DELEGATED DECISION

Address: 68-76 ALBERT ROAD YIEWSLEY

Development: Creation of two additional floors above existing building to incorporate 4 x 1-bed flats (Prior Approval)

LBH Ref Nos: 33654/APP/2020/2582

PROPOSED PARKING AND CYCLE STORAGE (1:200)

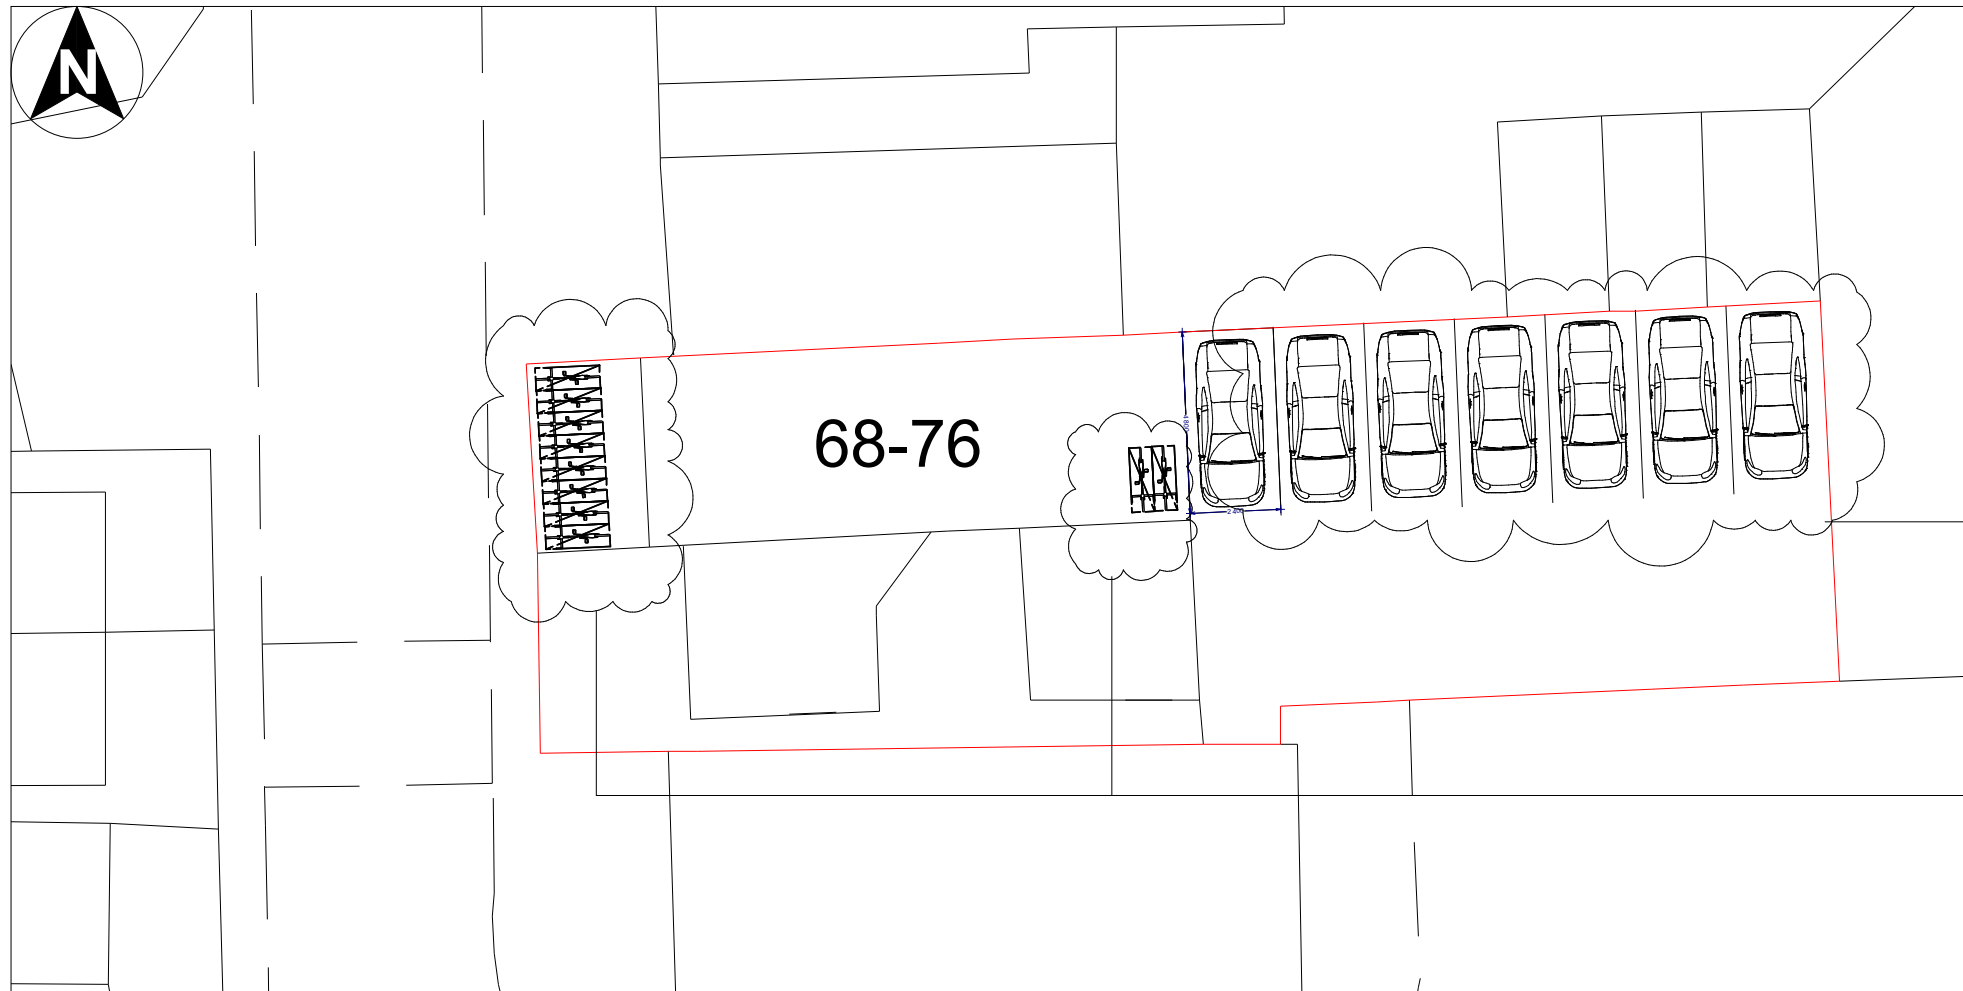
However, the Highway Authority are concerned that there is insufficient space for drivers to manoeuvre within the parking area at the rear of the proposed development. Manual for Streets (2007) advises that for perpendicular spaces, the area in front of parking bays should be 6 metres. The proposed development would only provide 5 metres. The Highways Authority are concerned regarding the restricted manoeuvring spaces in the proposed bays which would likely dissuade some residents from using the parking spaces, particularly if they are visiting their home for just a few minutes. This would displace parking on-street in judiciously presenting a risk to road safety, hindering the free flow of traffic and exacerbating parking stress in the locality.

To allay these concerns the Highway Authority asked the applicant to provide swept path drawings showing a car parking in each of the seven spaces. These drawings failed to demonstrate that a driver could safely and conveniently park in each space.

Management Policies (2020) which requires that 5% of all parking spaces should be provided with an active electric vehicle charging point with a further 5% having passive provision. For this proposal, the Highway Authority would require that 2no. car parking spaces have active electric vehicle charging points with all the remaining spaces having passive provision.

Whilst the number of cycle parking spaces proposed is policy compliant the Highway Authority considers that because they would be located at the front of the proposed development they will not be used. The cycle parking spaces in effect are located in the 'front garden' of the proposal immediately abutting the back of footway. In this location bicycles are vulnerable to being tampered with or stolen. The occupiers of the development are likely to consider that the risk of theft is so great that they would be deterred from owning one as they would have nowhere covered and secure to store it.

There are highway objections to this development as it is not in accordance with the Hillingdon Local Plan: Part 2 Development Management Policies (2020) Policy DMT 6: Vehicle Parking. There is insufficient space at the rear of the proposed development for vehicles to manoeuvre into every parking bay particularly when most spaces are occupied. In addition none of the car parking spaces are provided with electric vehicle charging points and the cycle parking provision is neither covered nor secure.

PROPOSED 3/F (1:100)

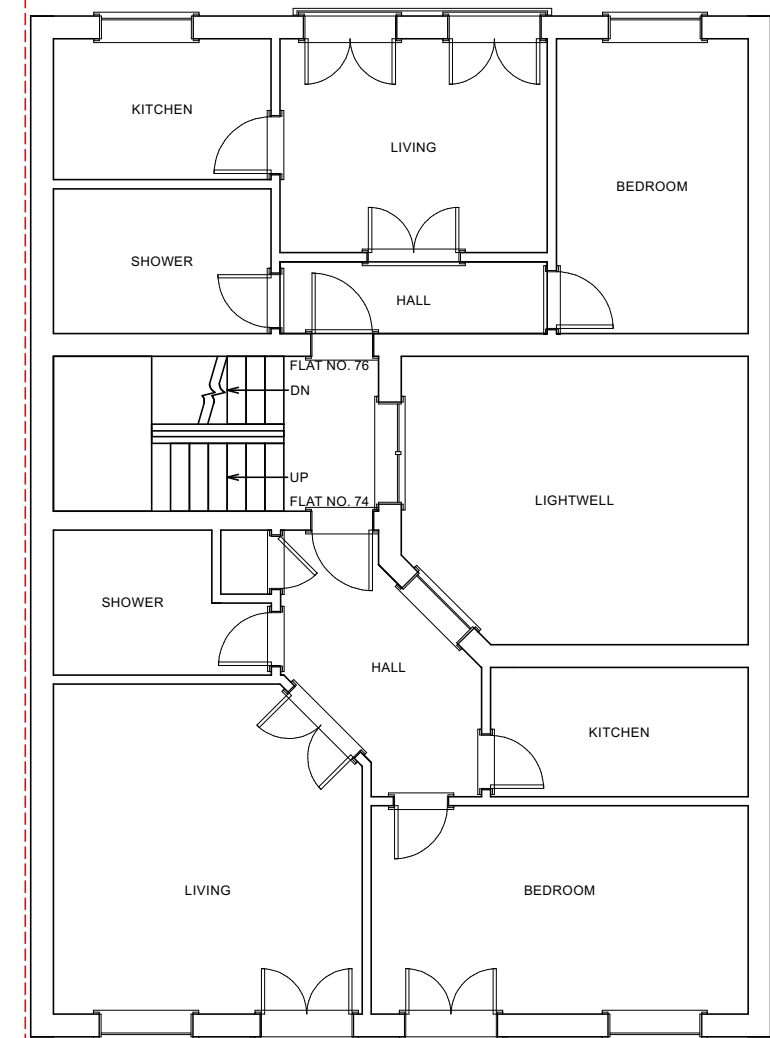
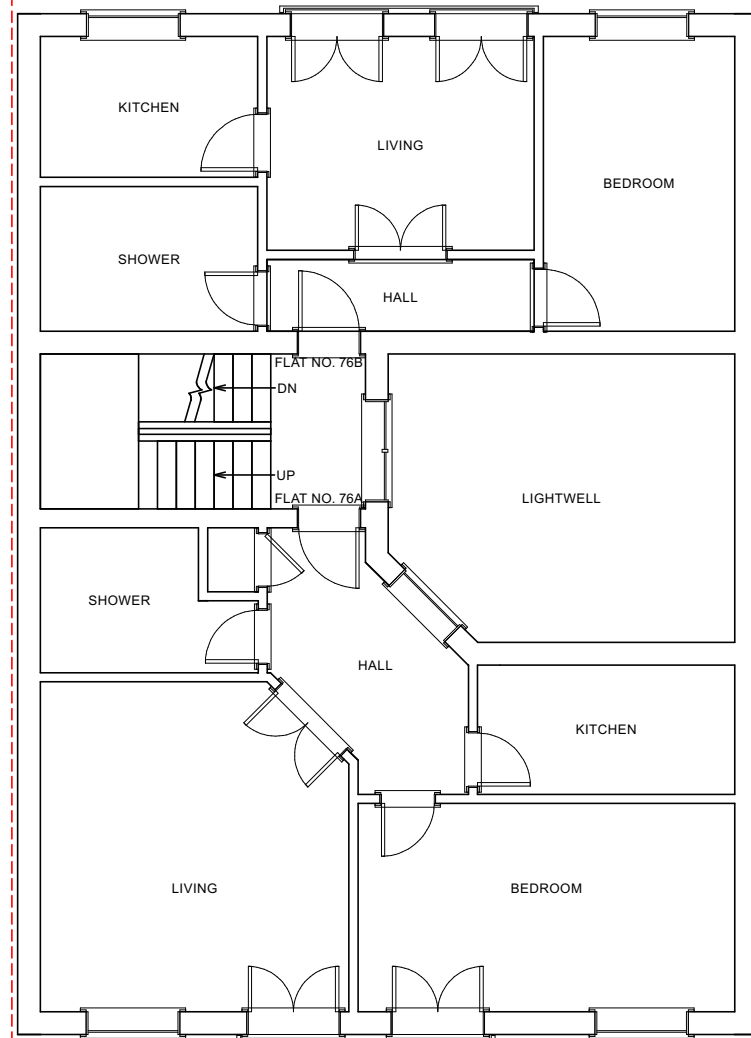
The exception to this is the provision of light and outlook to the kitchens in flats 76A and 76C which do not have any windows to allow light or outlook. As such the proposal fails to provide acceptable levels of light to the occupants of the two flats contrary to the requirements of Policy DMHB 16 of the Hillingdon Local Plan: Part 2 - Development Management Policies (January 2020).
